Consultation Response from: Planning Policy Group		
Address: Mytholmbridge Farm 36 Luke Lane Thongsbridge		
Proposal: Partial demolition of dwelling and erection of extensions		
Date Responded: 27th January 2022	Responding Officer: Amanda Potter	Responding Ref:

This proposal is for the partial demolition of a dwelling, erection of two storey side extension and rear extension, porch, link extension, detached garage and external alterations.

rear elevation - north east

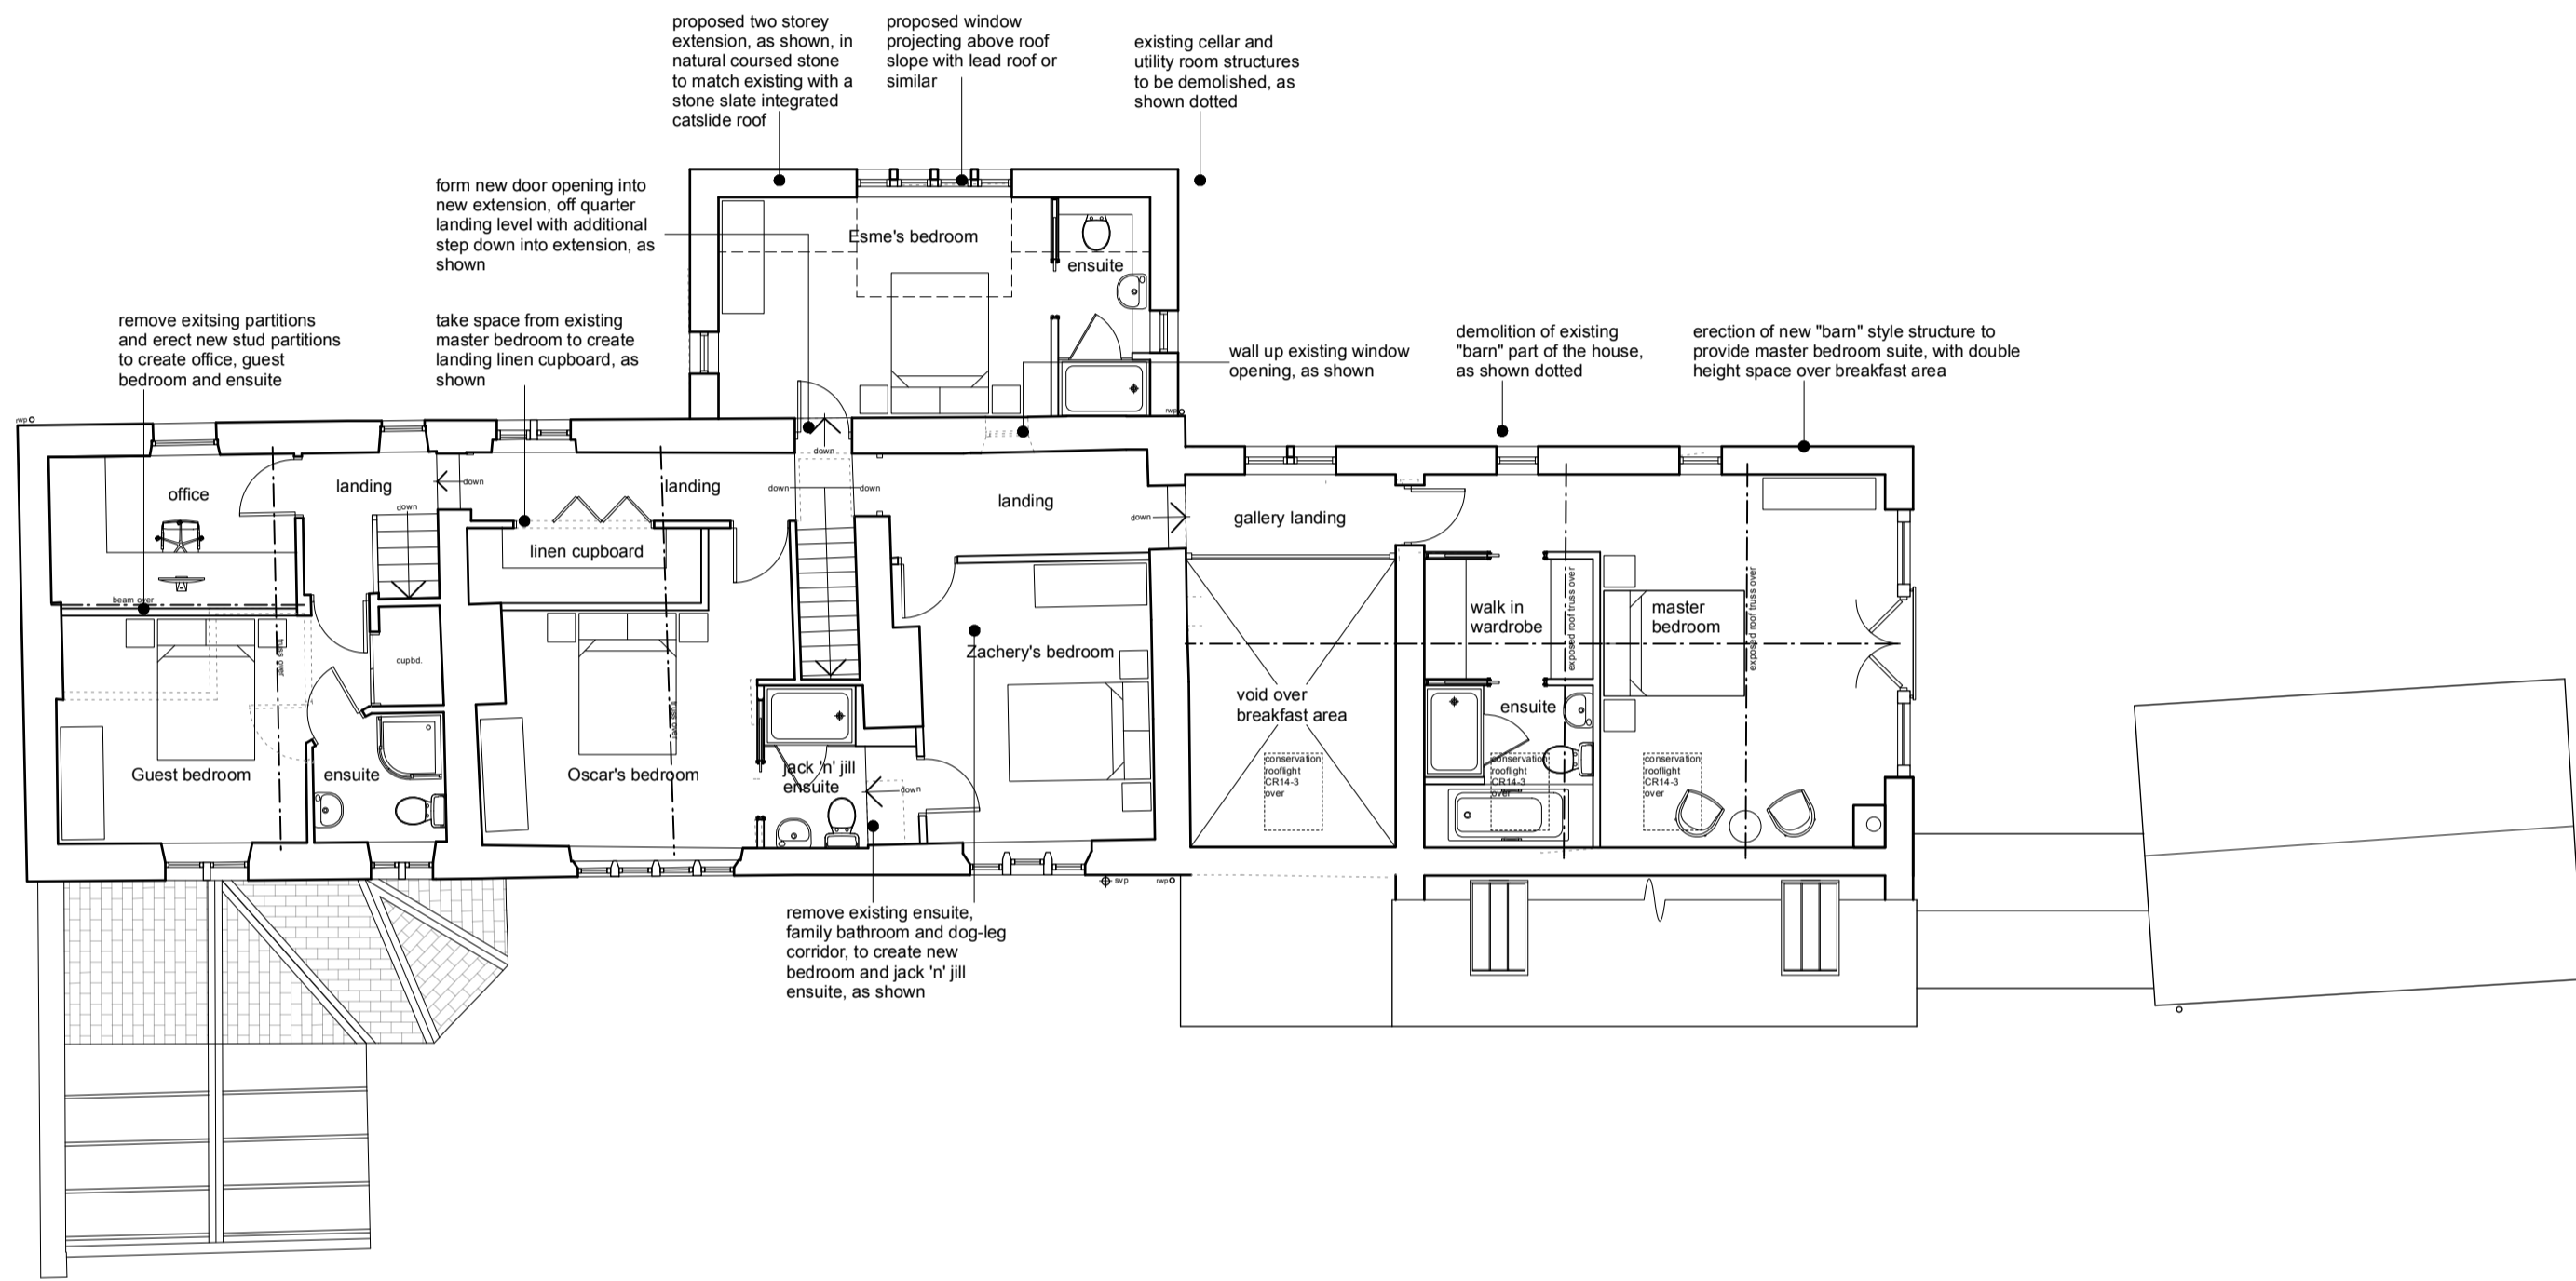
The building as currently standing, even with the addition of the conservatory/garden room, appears as a traditionally constructed farmhouse with subservient structures comprising the former barn and the rear lean-to. The replacement of these two subservient parts of the building with newly constructed two storey elements, even accounting for the use of reclaimed stone and the dropping of the roofline below

that of the farmhouse, totally changes the character of the building such that the original house is no longer dominant. This is especially evident on the rear elevation where the new building wholly eradicates the original character of the farmhouse. This is contrary to LP57 criteria a).

ground floor plan

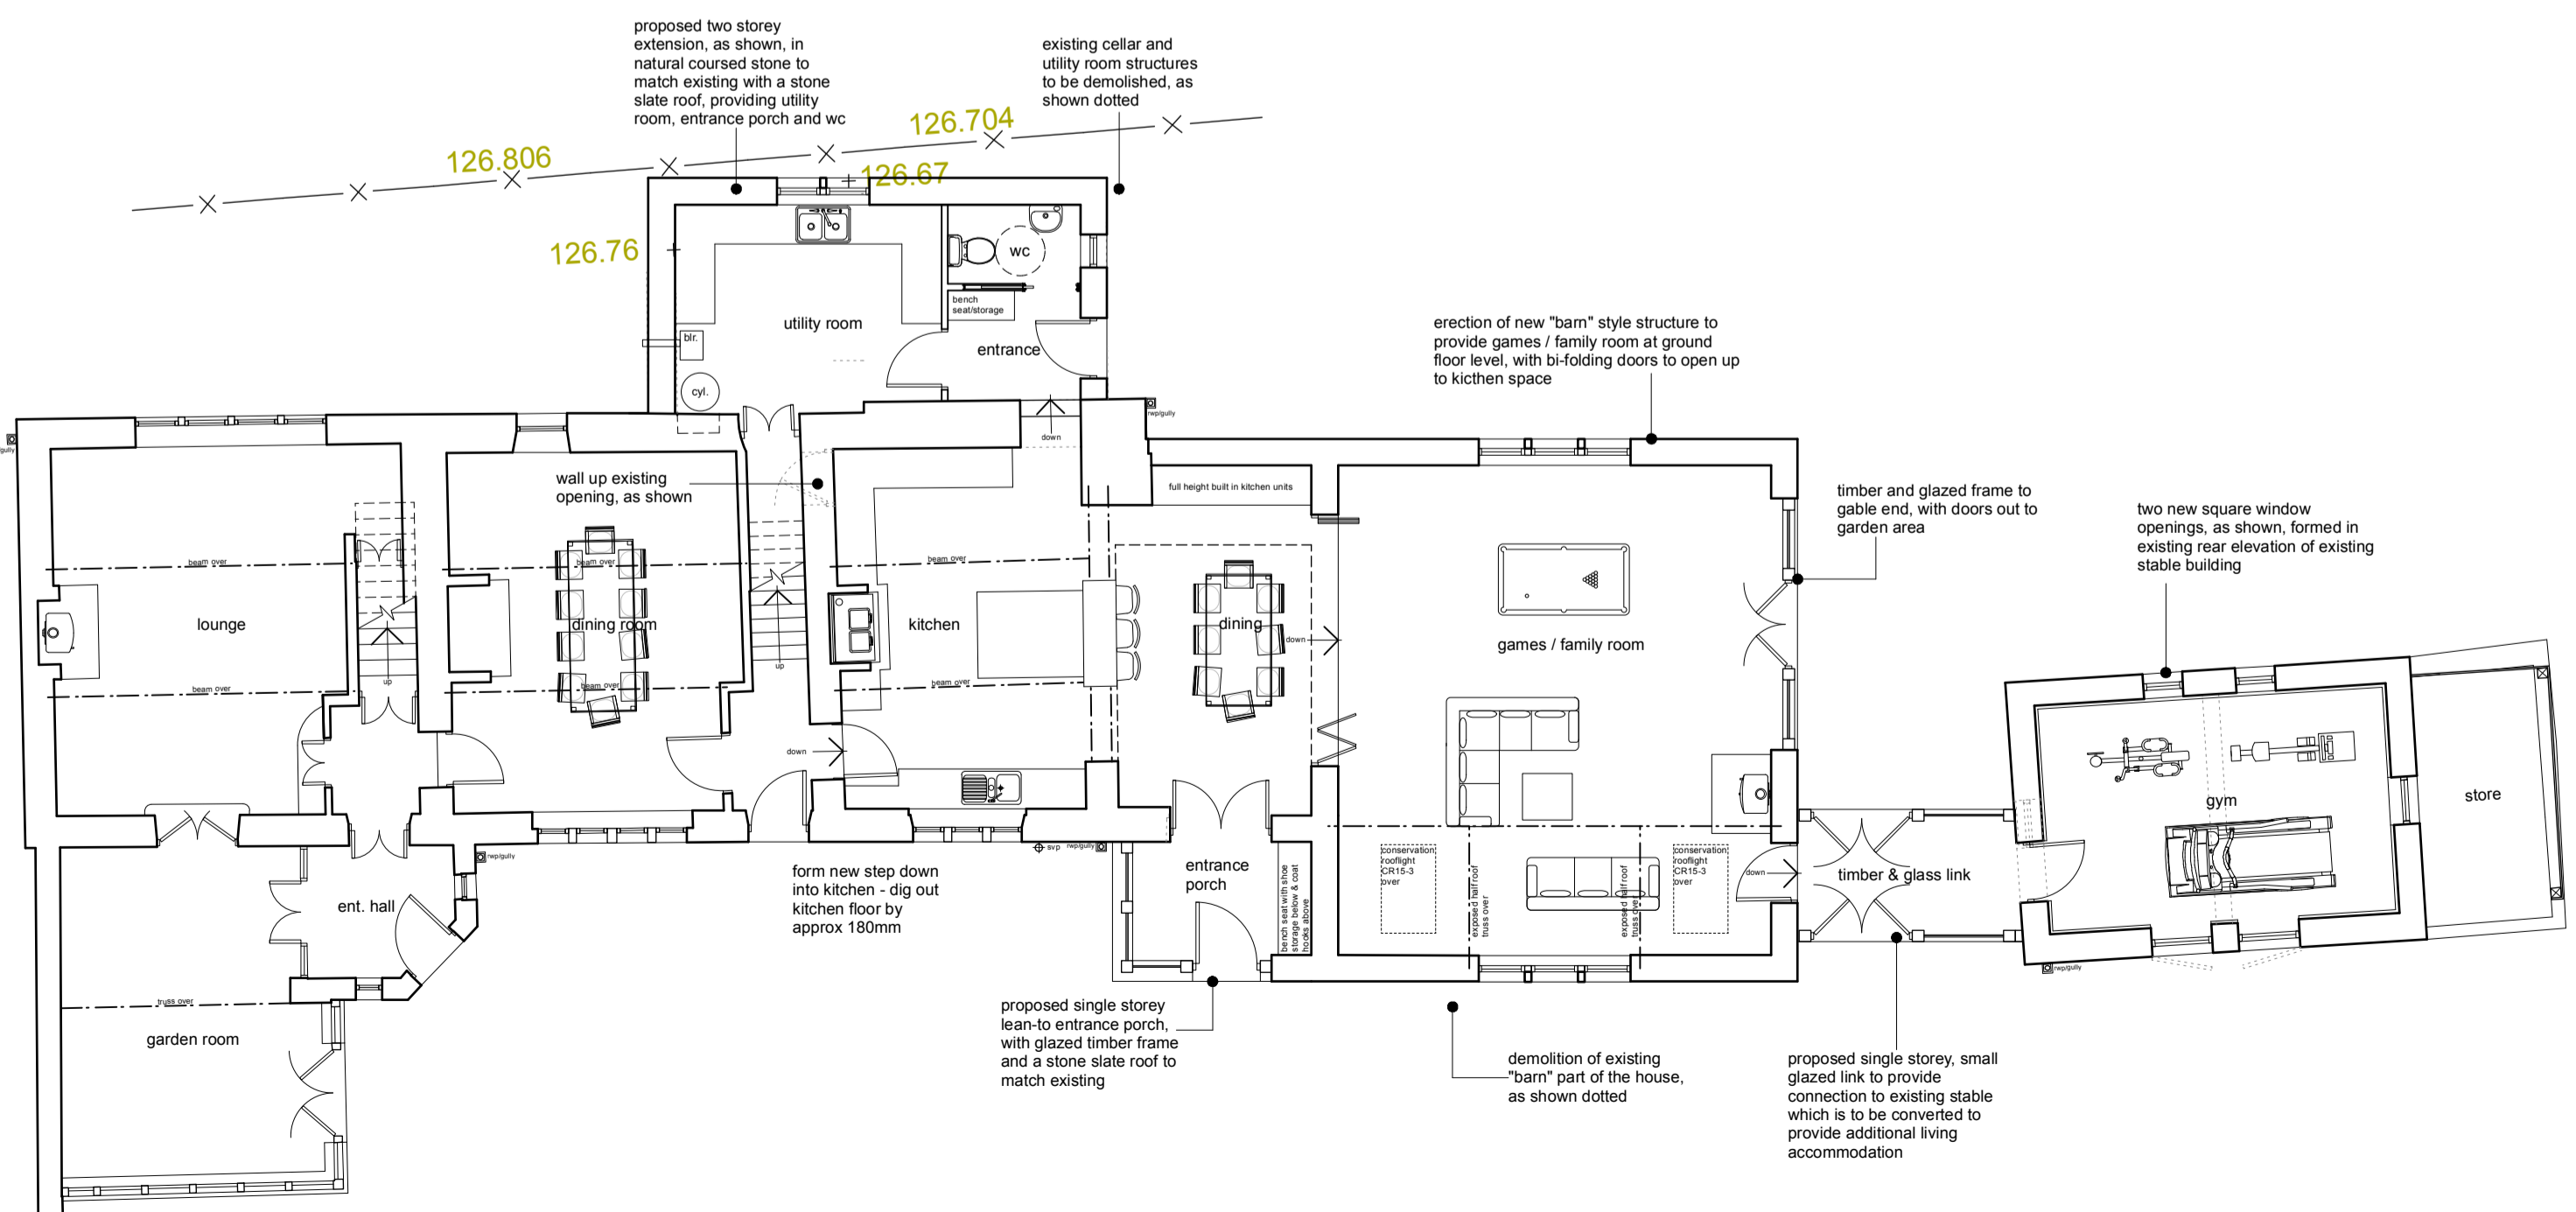
While the treatment of land around the building is not shown on the submitted drawings the installation of a door into the rear extension would suggest that circulation space is proposed to be created to the rear. As this is currently agricultural land this would constitute a change of use which would need separate consideration and may be inappropriate both in terms of NPPF paragraph 150 and LP57 criteria c) which states that the proposal should not result in a greater impact on openness in terms of the treatment of outdoor areas including hard standings, curtilages and enclosures and means of access.
